PLANNING CONSULTATION RESPONSE

Application No	2025/0849
Proposal	Redevelopment of builder's yard to erect two dwellings.
Address	Birkland Farm, Fullshaw Lane, Langsett, Sheffield, S36 9FD.
Date of Consultation Reply	03/02/2026
Consultee	Edward Jowett (Tree Officer)

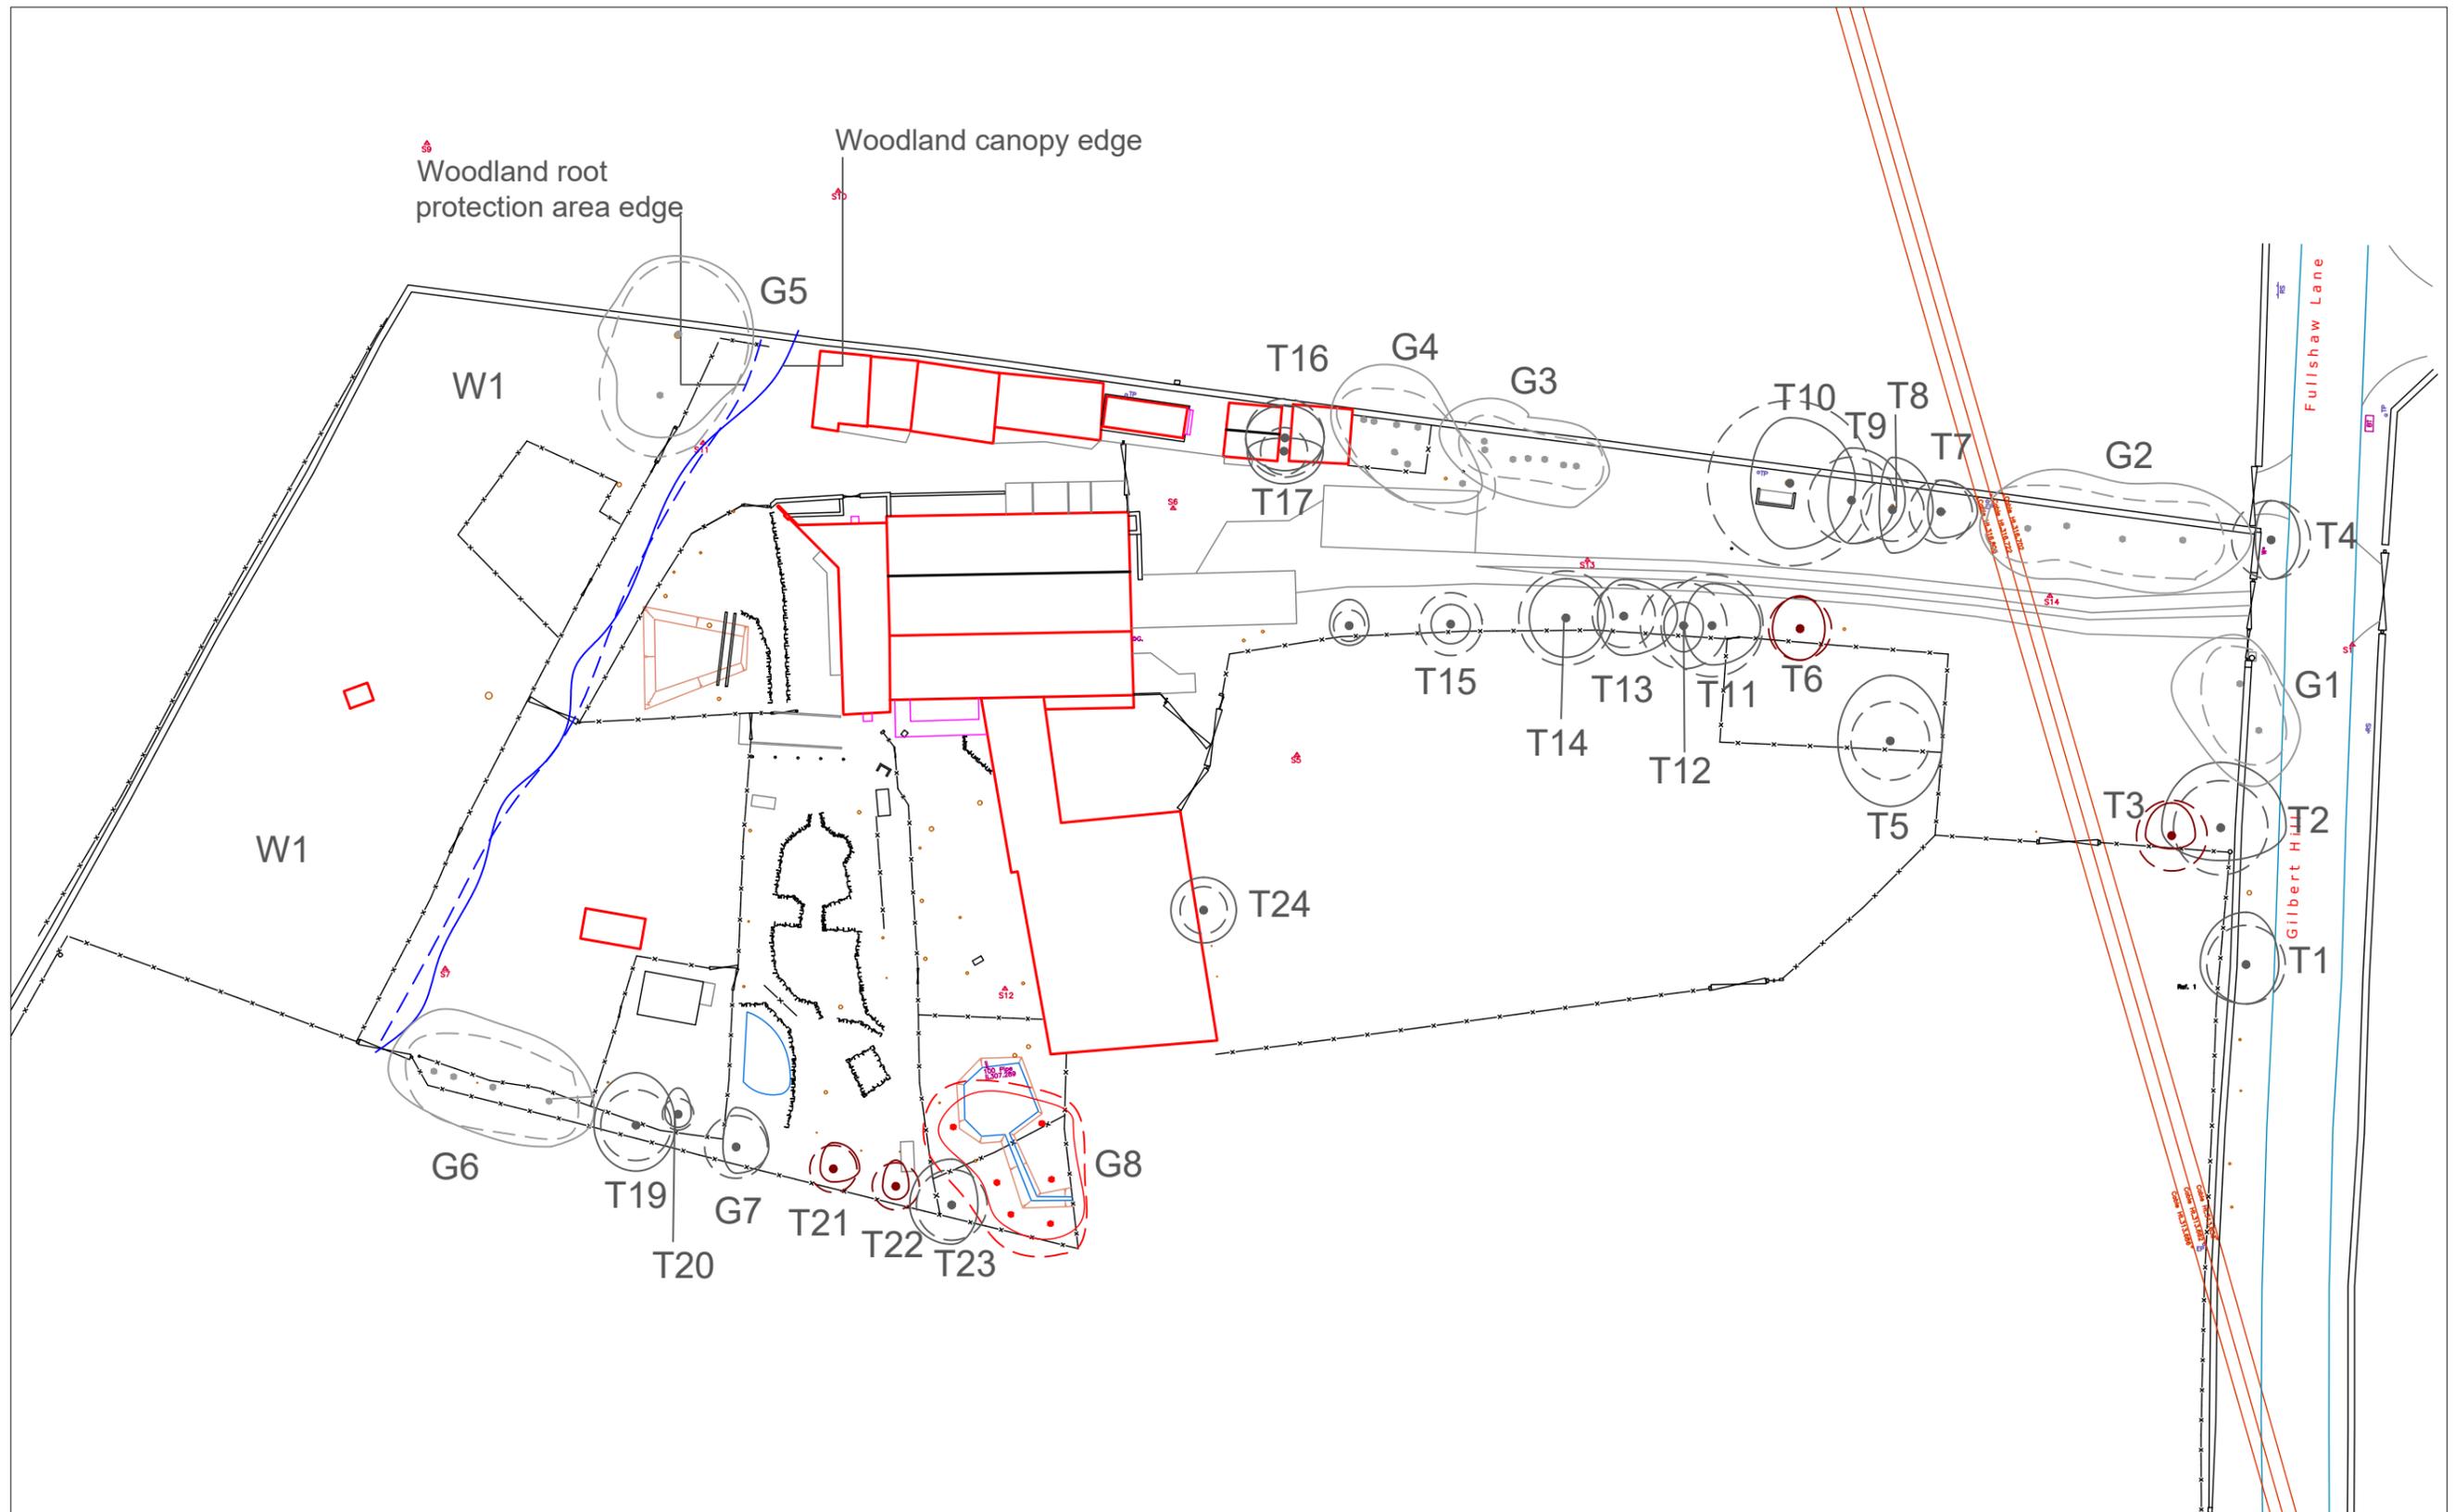
The trees on site are generally small specimens, however their number and location in an open exposed area means they are a prominent feature (especially the slightly better quality woodland group) and do have some amenity value. The proposed development does not require the removal of any tree to facilitate it with only four individual trees and a group of trees shown as requiring removal all due to Ash Dieback disease.

Providing the trees to be retained (as shown in the tree information) are properly protected then there is no objection to the proposal from an arboricultural perspective. In order to ensure this an arboricultural method statement will be required to deal with the physical protection as well as detailing any specialist construction techniques which may be required to ensure the trees safe retention.

Given that trees are to be removed I would also request that replacement planting be provided as part of the landscaping. The nature of the site means that significant replacement and new planting can be accommodated.

No development or other operations being undertaken on site shall take place until the following documents in accordance with British Standard 5837:2012 Trees in relation to design, demolition and construction - Recommendations have been submitted to and approved in writing by the Local Planning Authority:

Tree protective barrier details
Tree protection plan
Arboricultural method statement

No development shall take place until there has been submitted to and approved in writing by the Local Planning Authority, full details of both hard and soft landscaping works, including details of the species, positions and planted heights of proposed trees and shrubs; together with details of the position and condition of any existing trees and hedgerows to be retained. The approved landscaping details shall be implemented prior to the occupation the dwelling.
